# COUNTY COUNCIL'S RESPONSE TO CONSULTATION ON THE FOLLOWING DEVELOPMENT PROPOSAL

**Application No:** 17/02167/F-2

**Proposal:** Conversion of building from B1(a) Offices to 25 residential flats, with ancillary parking, bin storage and amenity area

**Location:** The Old Malthouse St Johns Road Banbury

Fig.7: Site Plan.

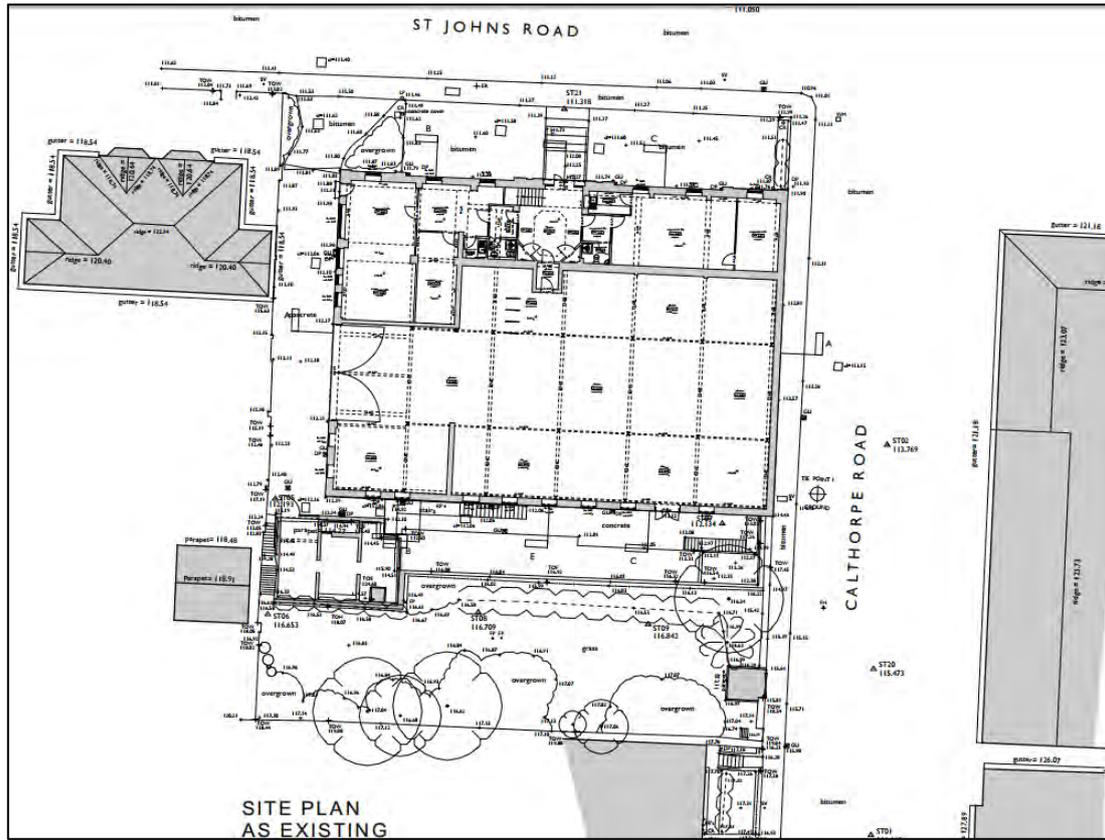
- The applicant wants to provide 25 vehicular parking spaces within the curtilage of the building. However, I do not think that the 25<sup>th</sup> parking space immediately to the north of the refuse and recycling bin store is suitable. There does not appear to be anything to stop the resident who is allocated that space parking too close to the doors to the store to enable them to be opened.

- The applicant needs to provide more details regarding the gated access to the parking and refuse storage area. They say that the separate pedestrian gate is to be operated independently. However, in the event of refuse bins being placed in the collection area and there being a gate post separating the pedestrian gate from the vehicular gate, there is only 2m of width in between that post and the refuse bins to allow a motorist to pass. This could lead to the resident who has been allocated that space parking to the north of the gates and impeding access to the rear of the building for pedestrians.

- The applicant has not explained how the large communal refuse and recycling bins will be dragged to the kerbside on St. John's Road on collection days. These are too heavy for residents to drag.

The applicant has submitted an amended site plan which shows that vehicular parking space No. 25 is to be situated immediately to the north of the doors to the north of the refuse and recycling bin store. The applicant is advised to use a barrier to make sure that the resident who uses the space does not park so that there is no room for the double doors to the refuse store to swing outwards in a northerly direction.

The applicant needs to provide more details regarding the gated access to the parking and refuse storage area. They say that the separate pedestrian gate is to be operated independently. However, in the event of refuse bins being placed in the collection area and there being a gate post separating the pedestrian gate from the vehicular gate, there is only 2m of width in between that post and the refuse bins to allow a motorist to pass. This could lead to the off-side of the vehicle colliding with the inner gatepost, and the resident who has been allocated that space parking to the north of the gates and impeding access to the rear of the building for pedestrians. The applicant should provide a vehicle tracking drawing which shows that a normal-sized car can reverse out of the space, turn and then pass through the gated entrance to the development when the bins are placed out for collection.

The applicant has provided an over-runnable area for pedestrians which is 2m wide. They will need to provide more details of how the gate for pedestrians, including disabled users is to be operated. They have described it as being accessible independently. This is important as this gate leads to the door from the under-croft of the building which is the only access to the building for wheelchair users.

The applicant needs to provide details of how large communal refuse bins will be dragged from the refuse storage area to the collection area on bin collection days.
